**Examining Authority’s Issue Specific Hearing 2 (ISH2) Wednesday 28 to Friday 30 January 2026 Supplementary agenda additional questions**

In response to the Examination Authority’s Action Points arising from Issue Specific Hearing 2 (ISH2) on 29<sup>th</sup> January 2026 the MCA would like to comment as follows at Deadline 4, Tuesday 10 February 2026.

Fig.1- MCA RAM & Restricted Visibility Stop SimOps Area

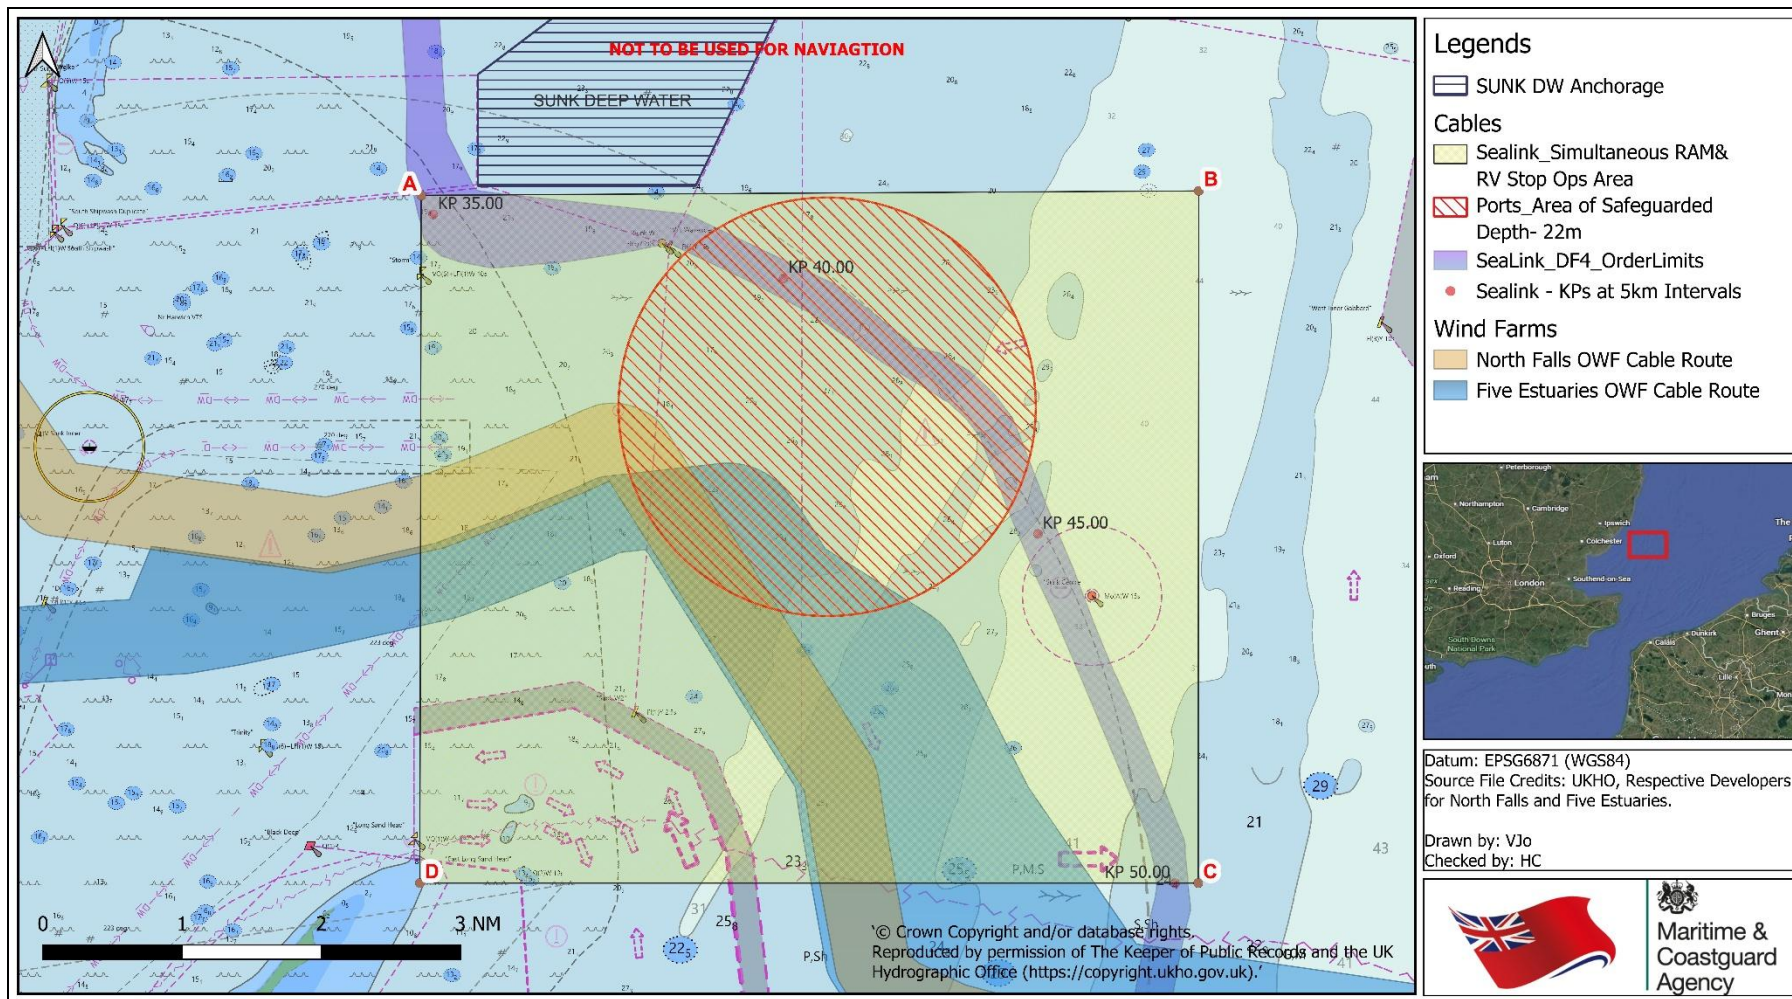
| 98. | MCA to provide the applicant with an updated defined area for the avoidance of concurrent restricted ability to manoeuvre activities and restriction on activities when visibility is poor in relation to Sea Link activities.   | MCA                      | DL4 | <p>As the National Competent Authority for the SUNK Vessel Traffic Services (VTS), the MCA requests that our defined area of interest (<b>figure 1</b> below) for Sea Link to commit to no concurrent activities with other projects <u>and</u> for Sea Link to cease operations in visibility of less than 2nm, is secured in the DCO DML as this is a key risk mitigation measure to preserve the safety of navigation in the SUNK area.</p> <p>Specifically:</p> <ol style="list-style-type: none"> <li>1) No Sea Link project activities involving vessels Restricted in Ability to Manoeuvre (RAM) to operate concurrently with activities involving RAM vessels planned by the Five Estuaries and North Falls offshore windfarm project in the SUNK area (or</li> </ol>  |

- 2) No Sea Link project vessels with Restricted Ability to Manoeuvre (RAM) (cable laying, UXO clearance, survey) are to operate when visibility is below 2 nautical miles within the MCA's defined area in **figure 1**.

- 1) The defined area of interest in **figure 1** is a relatively small area of navigable sea room considering the size and draft of the vessels involved. Pilot boarding/dis-embarking is an 'area' and not a specific point. Vessels are usually requested to come to a position 1NM to the east of the pilot boarding area or 1.5 northeast for the ultra-large vessels. The vessels are then given a heading to board which could be any heading based on the weather / sea conditions. As such, vessels are boarded anywhere to the east of a line drawn North-South through the pilot diamond, including in the anchorages. The same applies to vessels disembarking a pilot which could be anywhere in (or close) to one of the Deep-Water Routes in the Sunk Inner.

|  |  |  |  | <p>2) Additionally, the MCA is requesting a larger defined area of interest <b>figure 1</b> than was previously permitted for the North Falls &amp; Five Estuaries projects. When those projects were approved, both were located to the south of the area, which still left a small section of navigable sea room to the north for other activities. However, the Sea Link project now occupies the northern part of the area significantly reducing the remaining safe sea room and further limiting the ability to conduct marine operations or transits to and from PLA and HHA.</p> <p>3) This is further compounded as almost all vessels exit the Sunk Inner to the Southeast to follow the IMO routing measure in the Strait of Dover which is considered as one of the busiest and most complex shipping lanes in the world. If all three project operations were taking place at the same time, the southeast corridor would be reduced to less than 1NM wide.</p> <p>4) Also, a recent trend is that, due to the northward migration of the Long Sand bank (within the SUNK area), the larger vessels using the Long Sand Head two-way route increasingly tend to divert into the Sunk Inner (north of the magenta line marking the northern limit of the LSH route), to maintain safe navigable depth. This behaviour further reduces available sea room particularly when vessels are simultaneously outbound from the PLA or HHA and can therefore create additional navigational constraints. This can be seen in <b>Figure 3</b> attached below, sourced from applicants' submission APP-284- Fig. 6.4.4.7.4.14.</p> |
